Epping to Thornleigh Third Track Proposal. Application number SSI 5132.

I/we object to the Epping to Thornleigh Third Track Proposal and consider that the EIS is inadequate and does not address the full impact of this proposal. It will cause untold damage to the health of residents and to the fabric of the Beecroft Cheltenham Heritage Conservation Area. Do not approve this project, reconsider the alternatives and protect the community.

Figure S.6 Cross-section and elevation - New Cheltenham Station concourse building (see also S.5 for artist's impression)

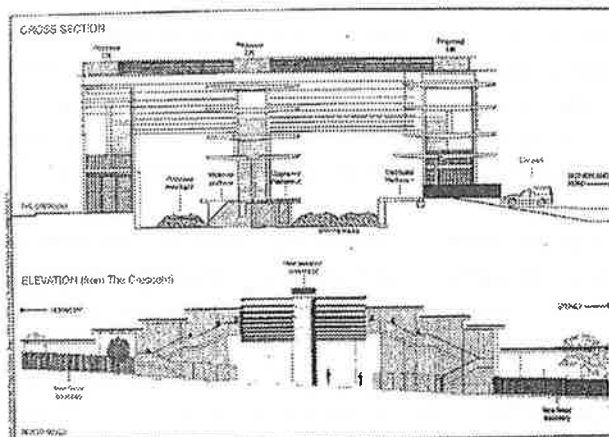
- The proposed redevelopment of Cheltenham Station shows no regard for the HCA. The visual impact of the proposed 13m high glass and steel concourse is totally unacceptable in this HCA.

Figure 5.3 Future Cheltenham Station layout

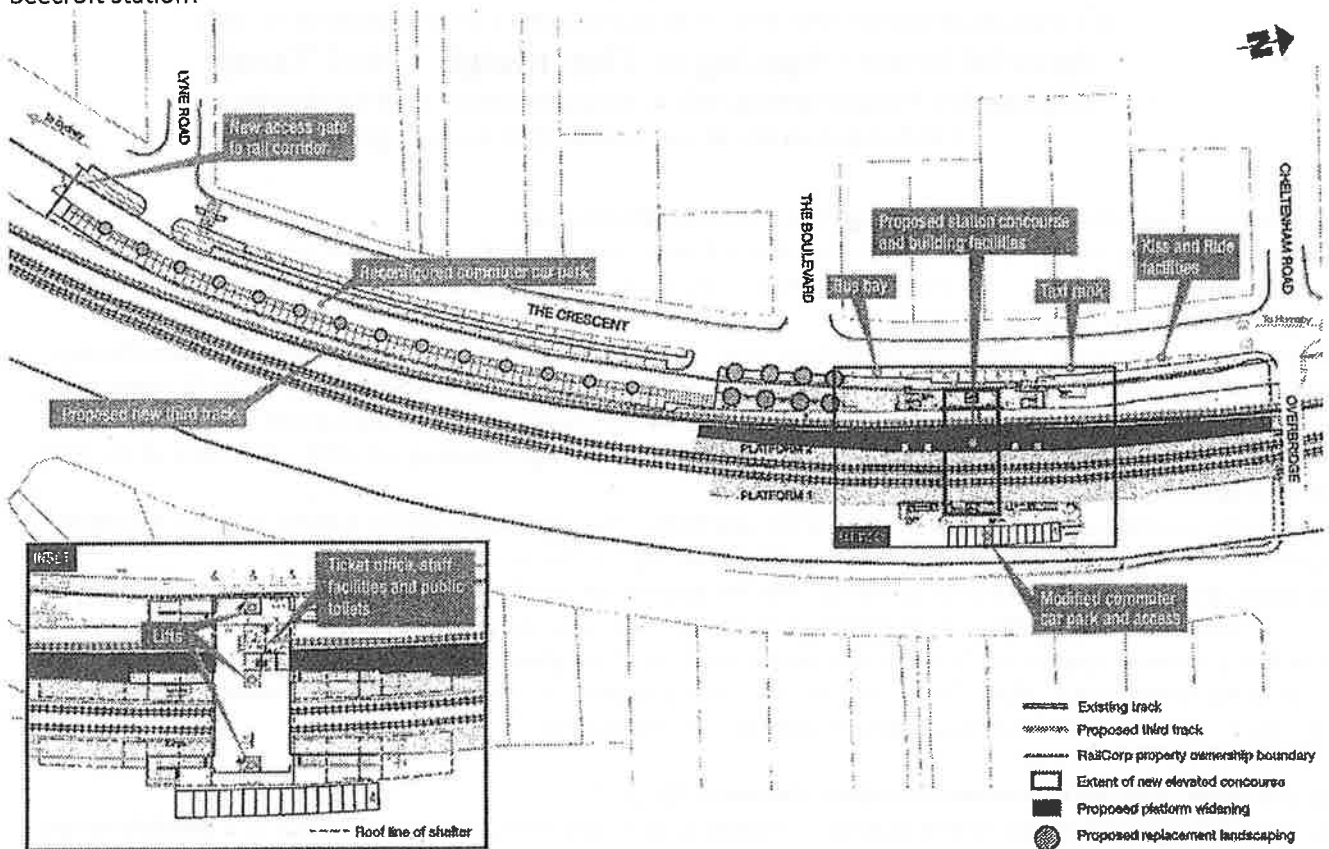
- There has been inadequate assessment of the project's impact on the fabric of the Beecroft Cheltenham Heritage Conservation Area (HCA).
- The plan given for Beecroft Railway station Precinct is vague. The relationship to the trees, playground and original 1895 platform located south of the present station is not shown. A fourth track is shown on the eastern side. The plan does not include urgently needed lifts to allow disabled access at Beecroft Station.
